**Essex County Council (ECC) - Written summaries of
Oral submissions made at Issue Specific Hearing (ISH) 1 and 2 (2 April to 8 April 2025)**

ISH 1 (2 April 2025 to 4 April 2025)

Coordinate system: OSGB 1936 British National Grid
 NMP/APS data provided by client.
 Contains Ordnance Survey data © Crown copyright and database right 2023.
 This material is for client report only © Wessex Archaeology. No unauthorised reproduction.

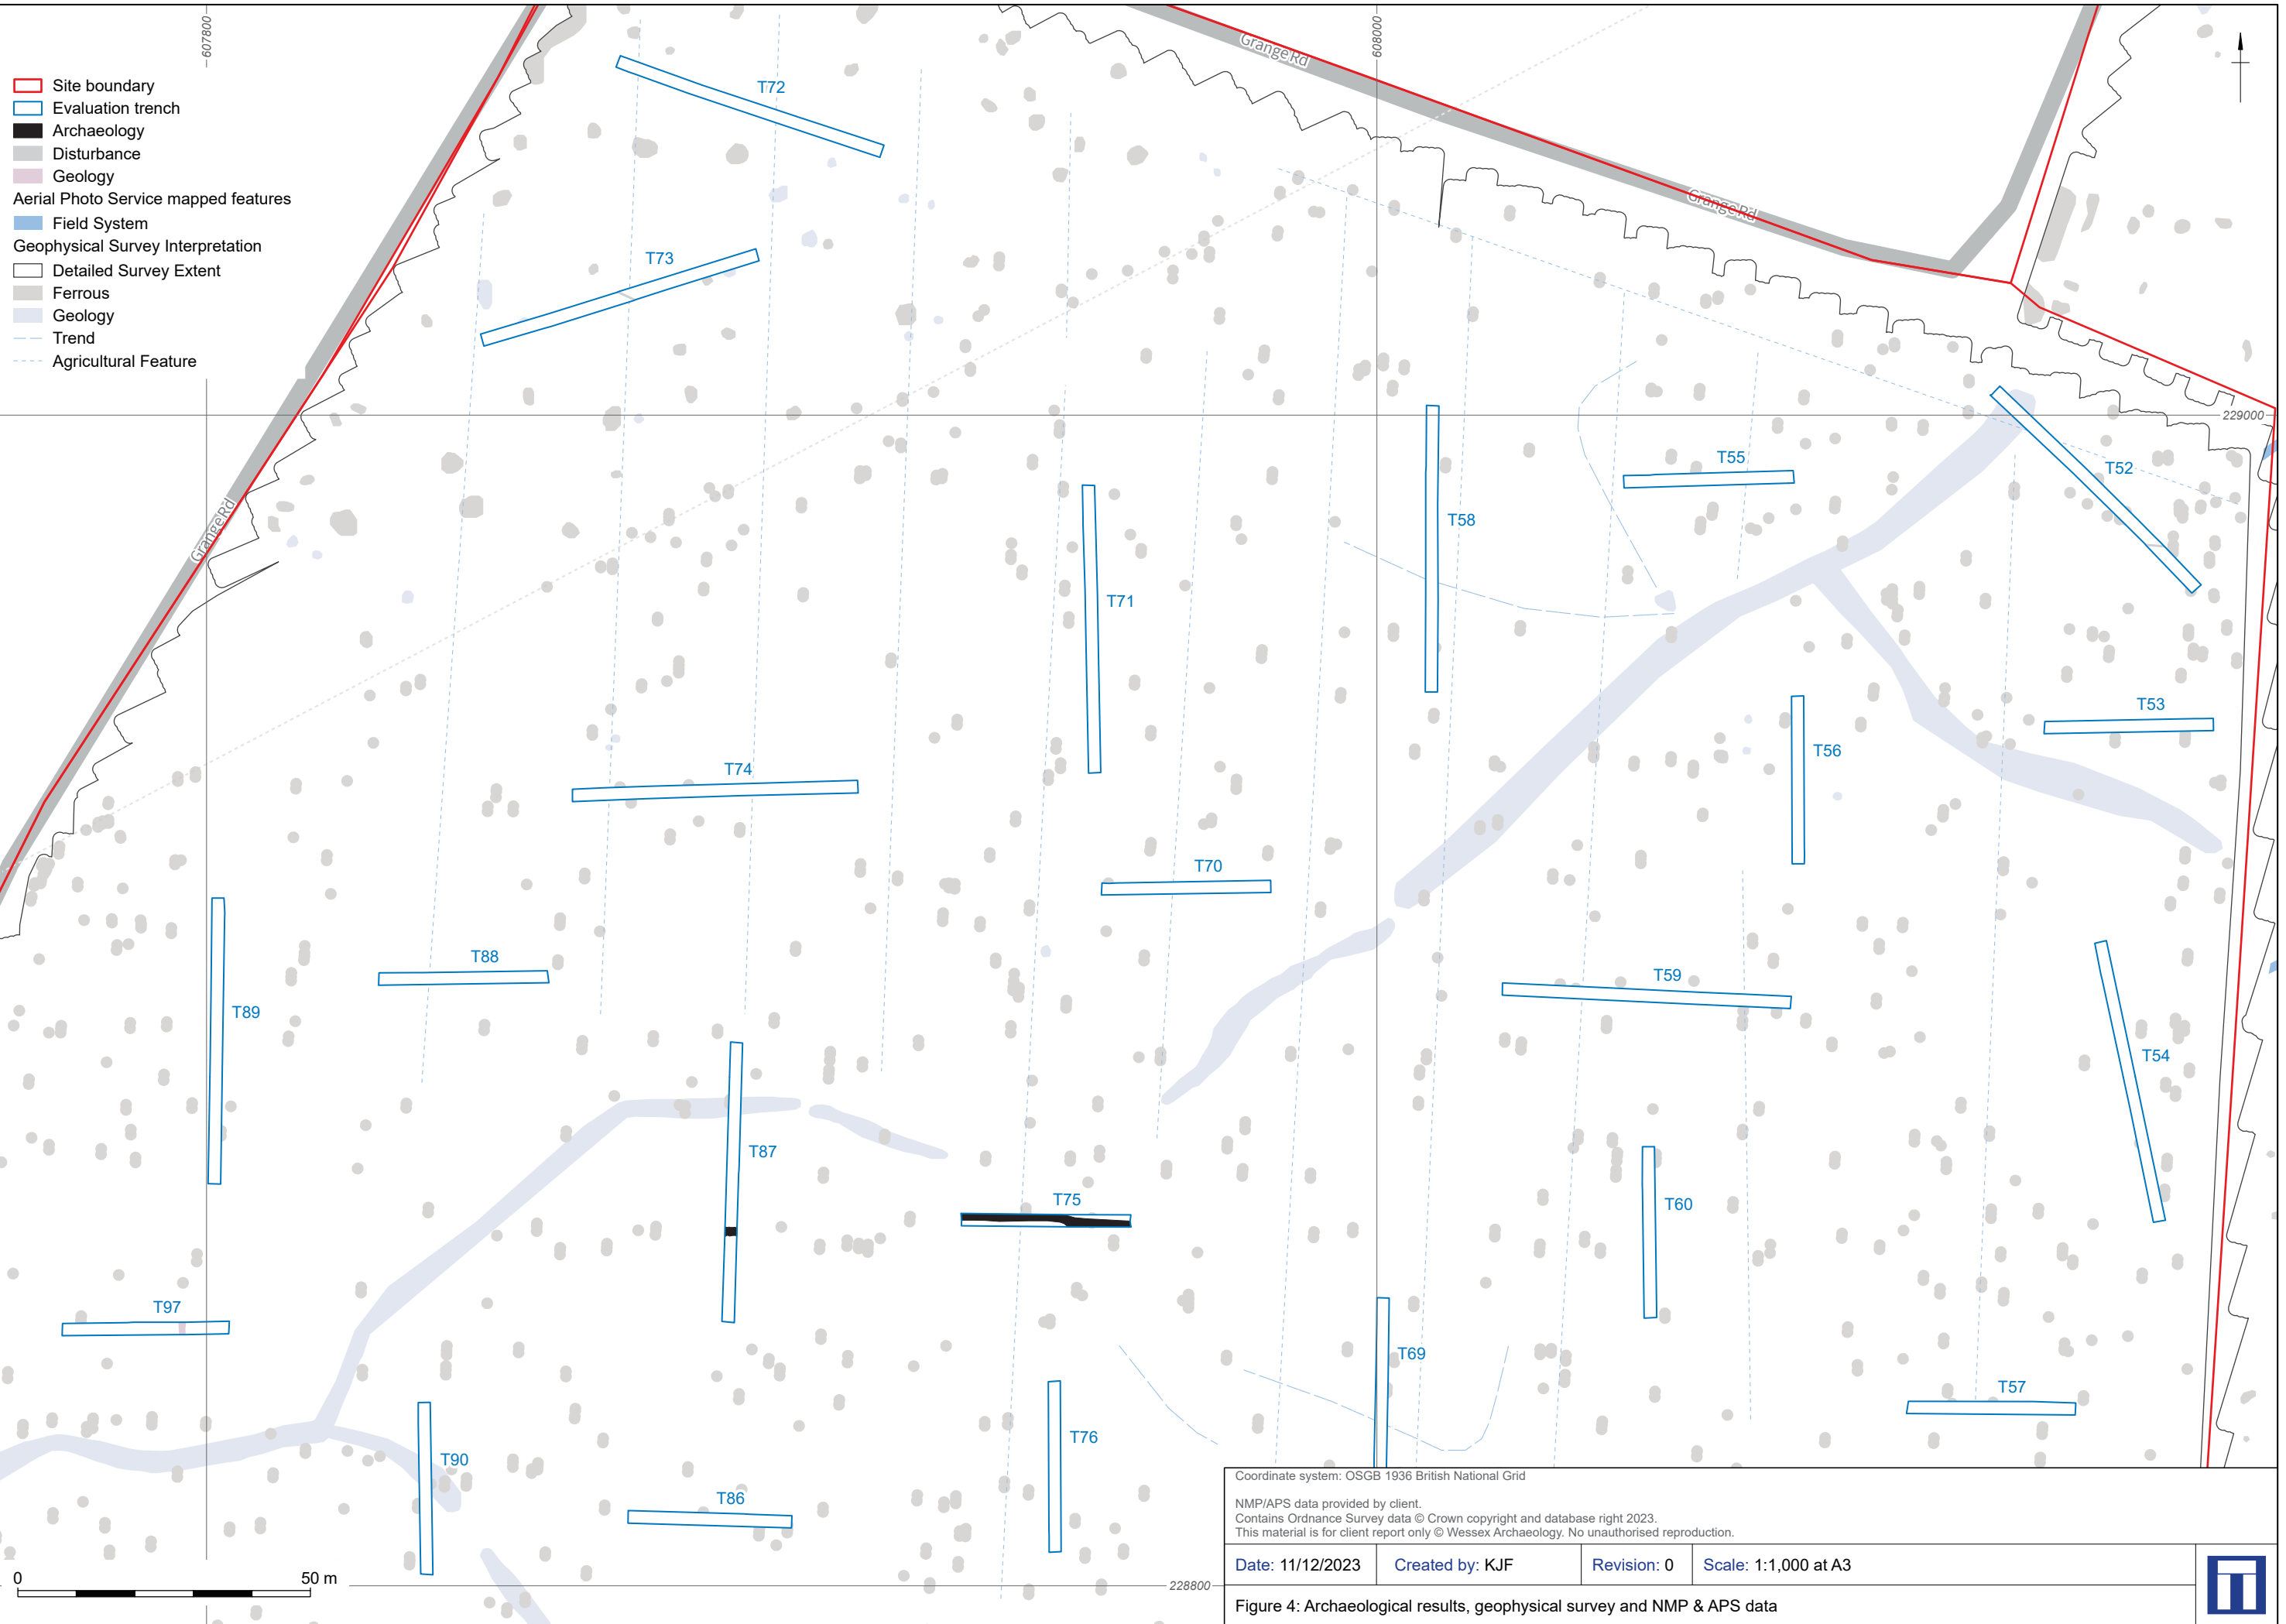
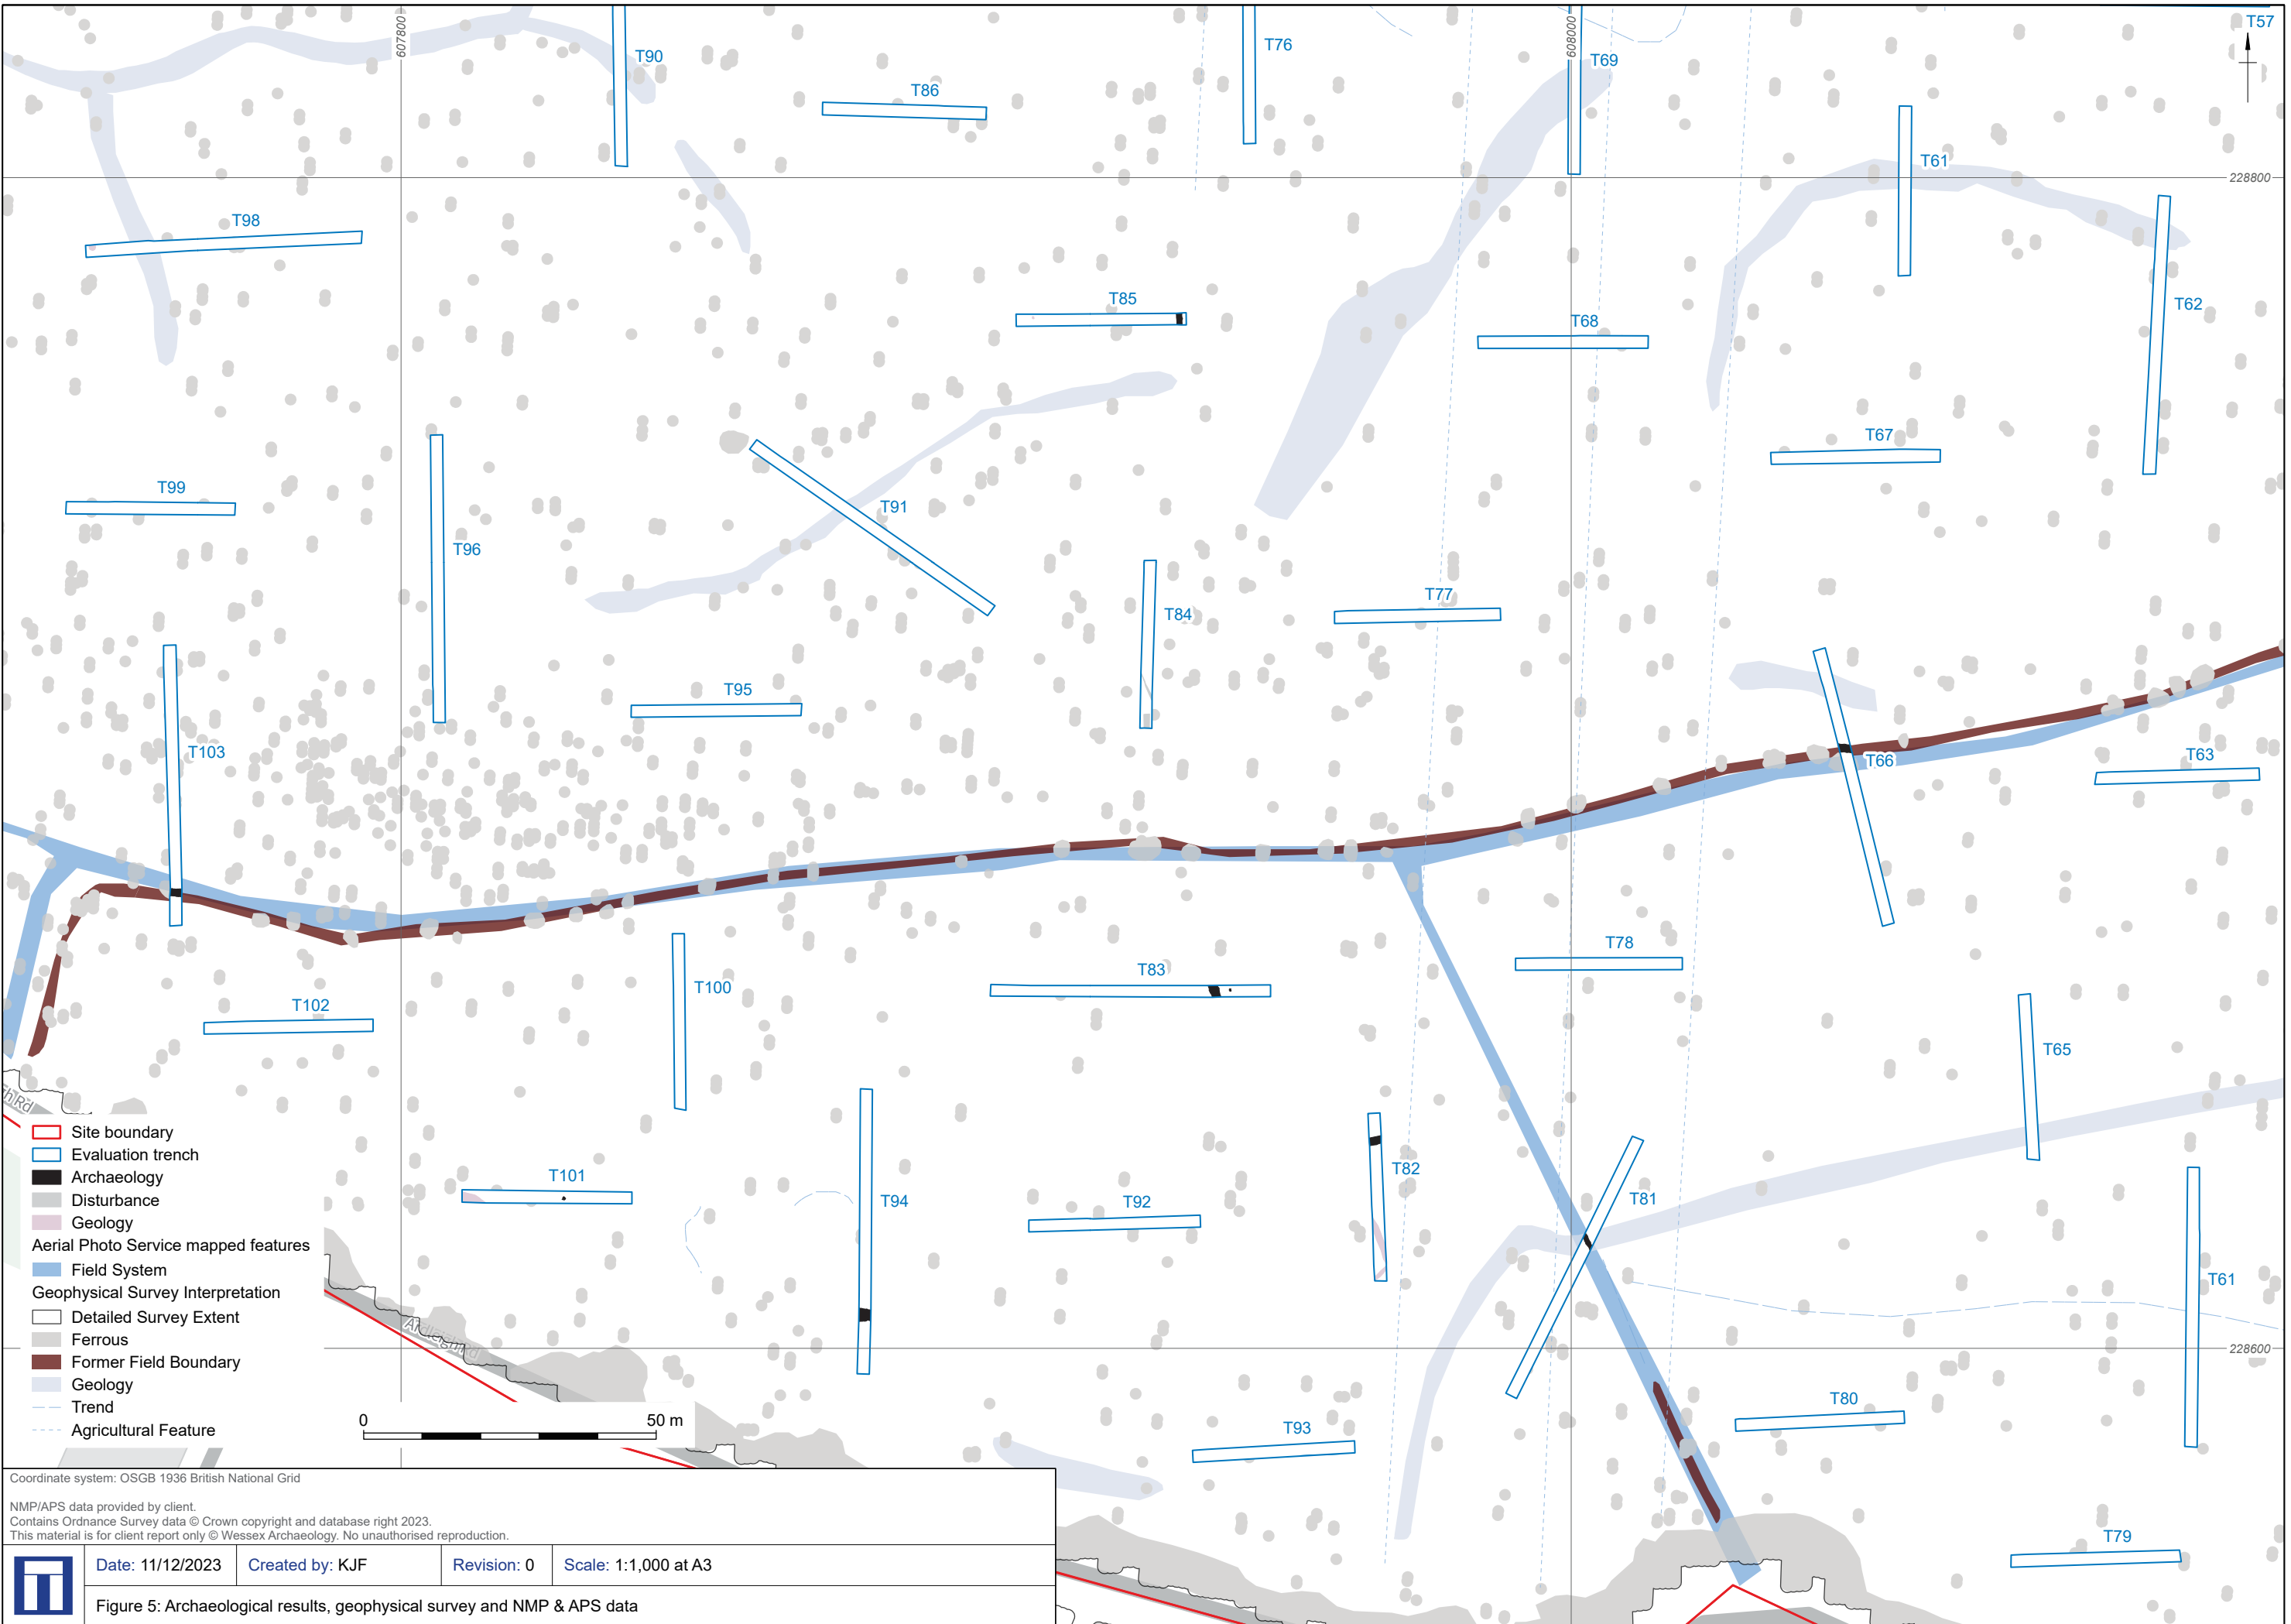
The archaeological heritage assets listed in document APP-039 have been largely identified through desk-based research and non-intrusive methods. These methods can only provide an indication of the potential for archaeological features. A geophysical survey is dependent on the receptiveness of the soils and geologies and a number of other factors in its effectiveness to identify below ground archaeological remains. It would not be able to provide sufficient information on the significance of any potential archaeological deposits located below ground. This is almost impossible to state with confidence, in terms of what the applicant consider significant in terms of EIA. Without a level of trial trench evaluation verification is not possible.

For the two areas that have been trial trenched, some areas did correspond with the geophysics, but other areas there were features that were not picked up by the geophysics. So we do not have enough information from the trial trench evaluation that have taken place to date to state, again, with confidence, that the non-intrusive methods that have been carried out so far are providing a reasonable account of what archaeology maybe within the development area and what archaeology may be impacted.
